**Mr. H. Krall, Brookenbee Cottage, Brook Lane, Rustington,
West Sussex. BN16 3JL.** [REDACTED]

Concerning planning application A/23/15/005. out.

Title
HIGHWAY ACCESS PLAN

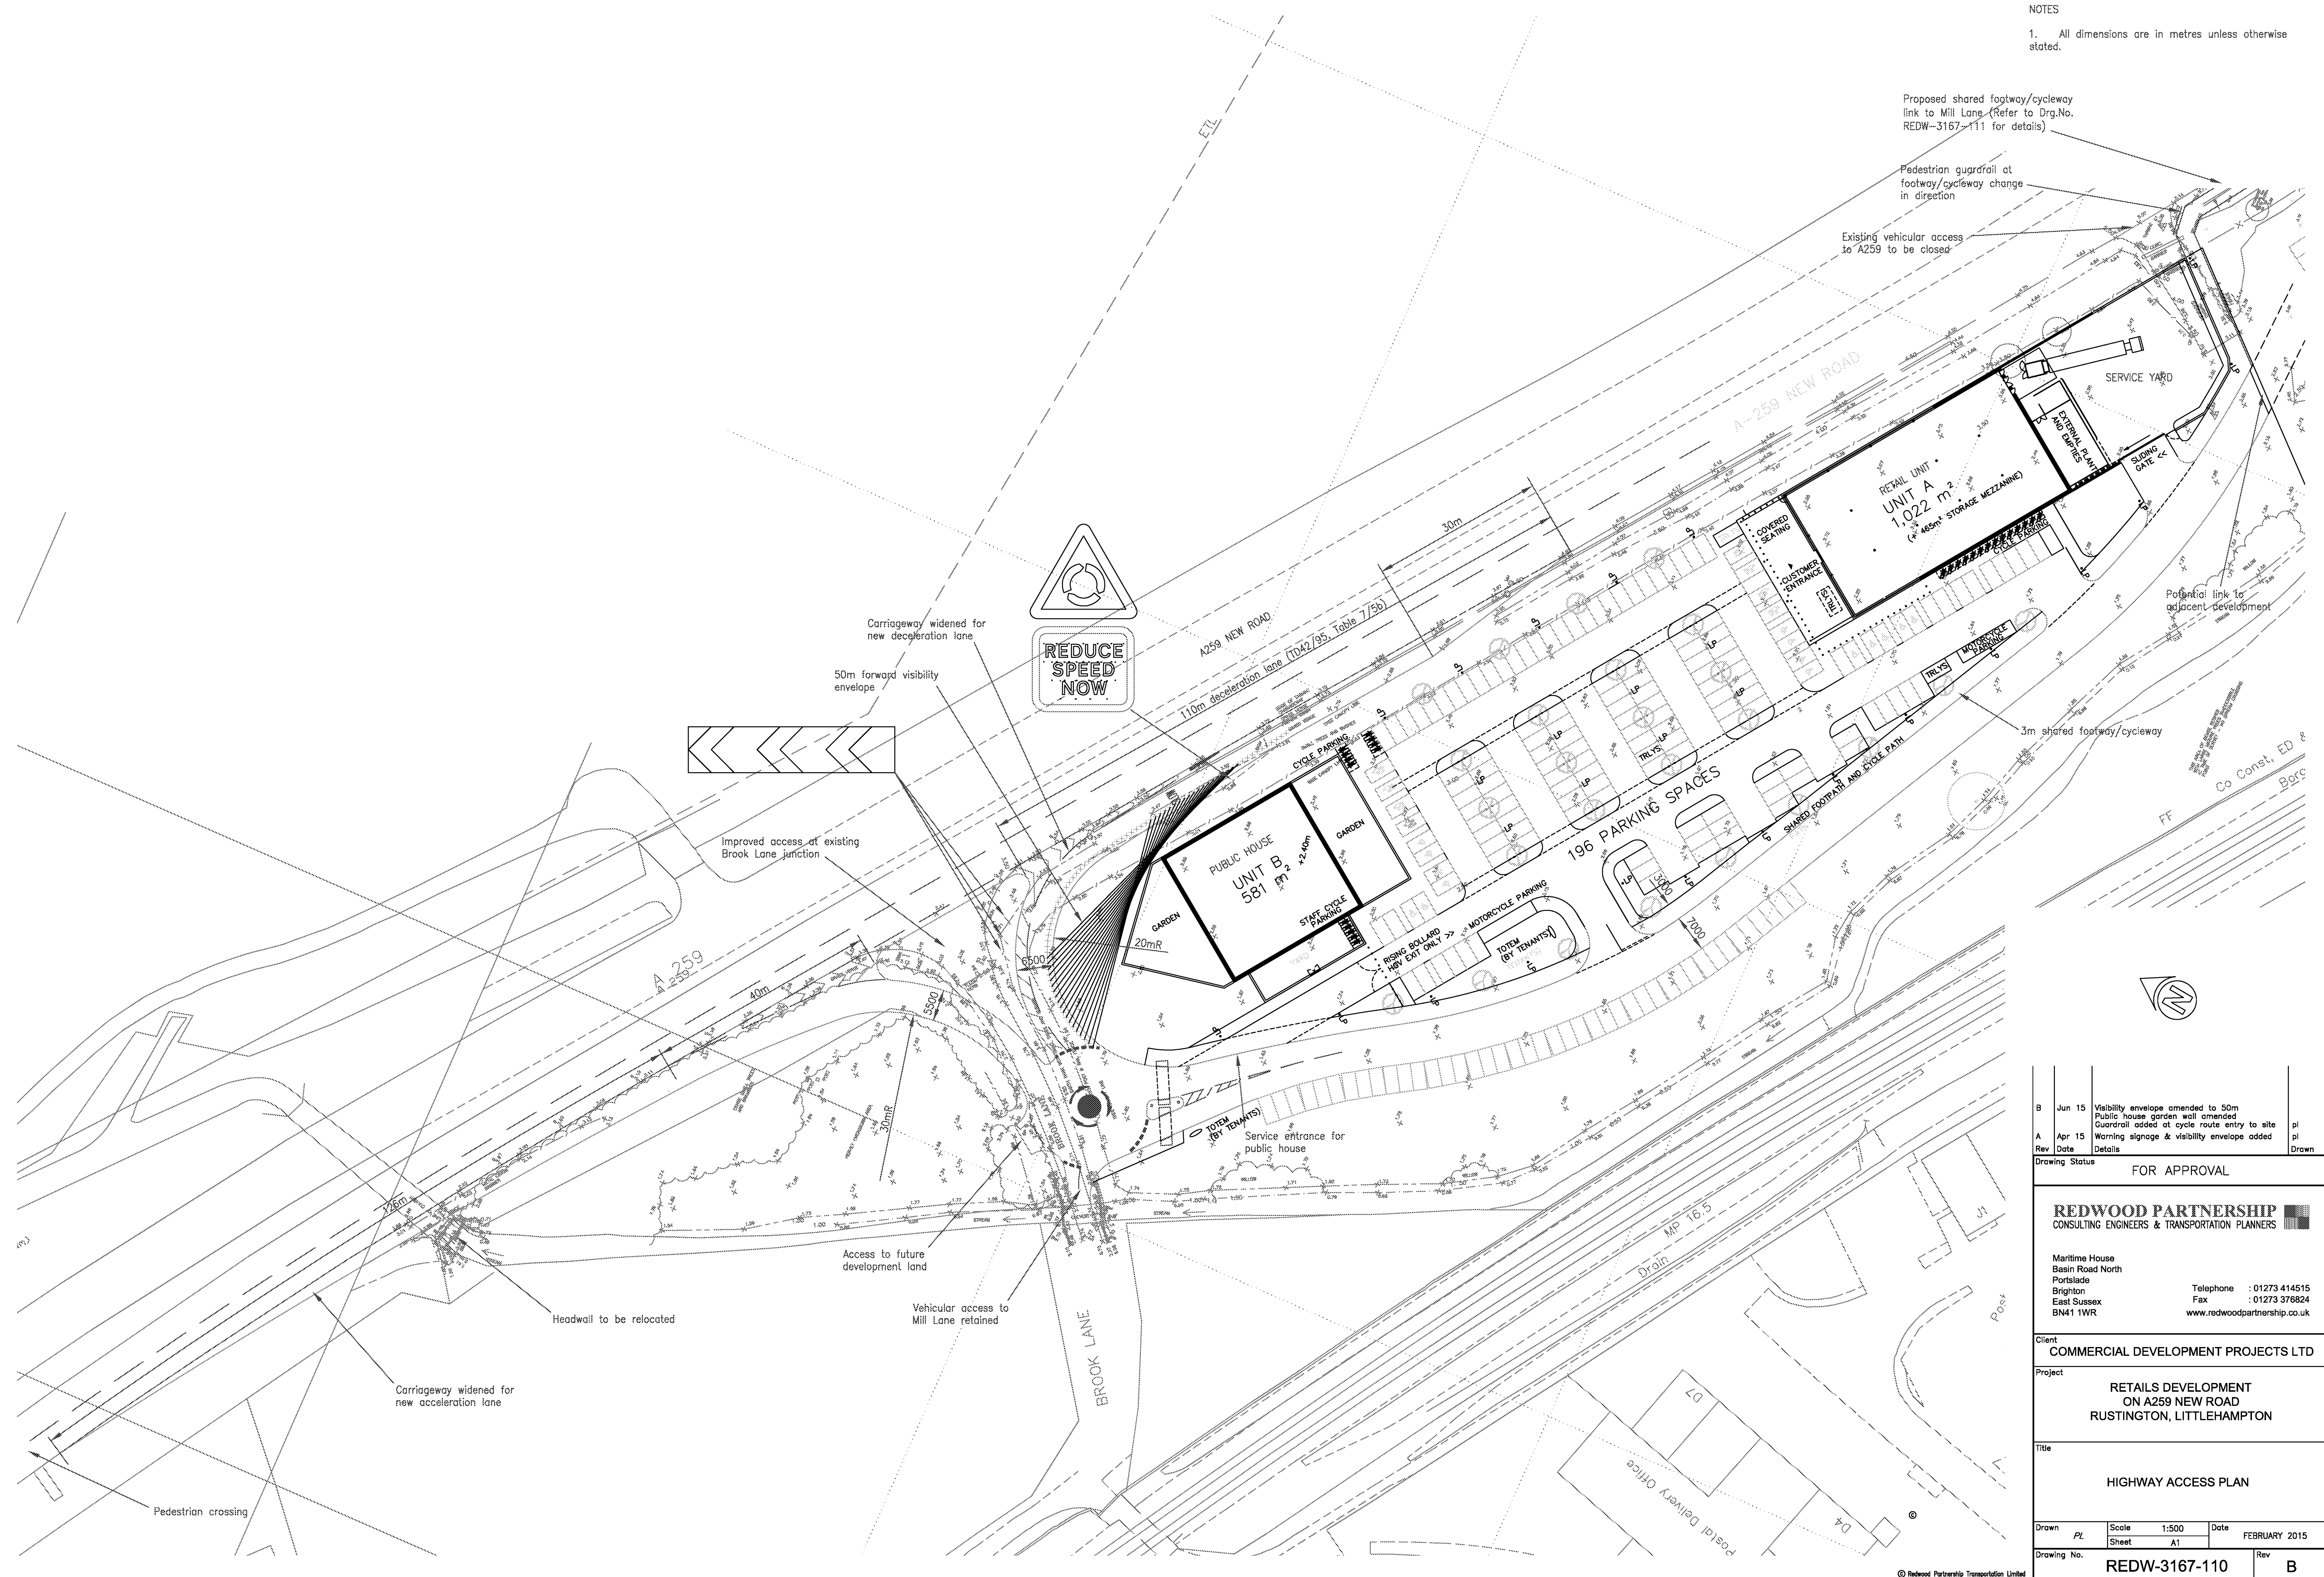
The roundabout is too close to the dual carriageway, making entering dangerous.
This is the only safe overtaking place for miles.
I am sure your planners will see the health and safety issues.

My interest in this proposal is as a resident of Brook Lane. The lane is frequently entered by large service vehicles. And the roundabout so close to the main road would be restrictive.
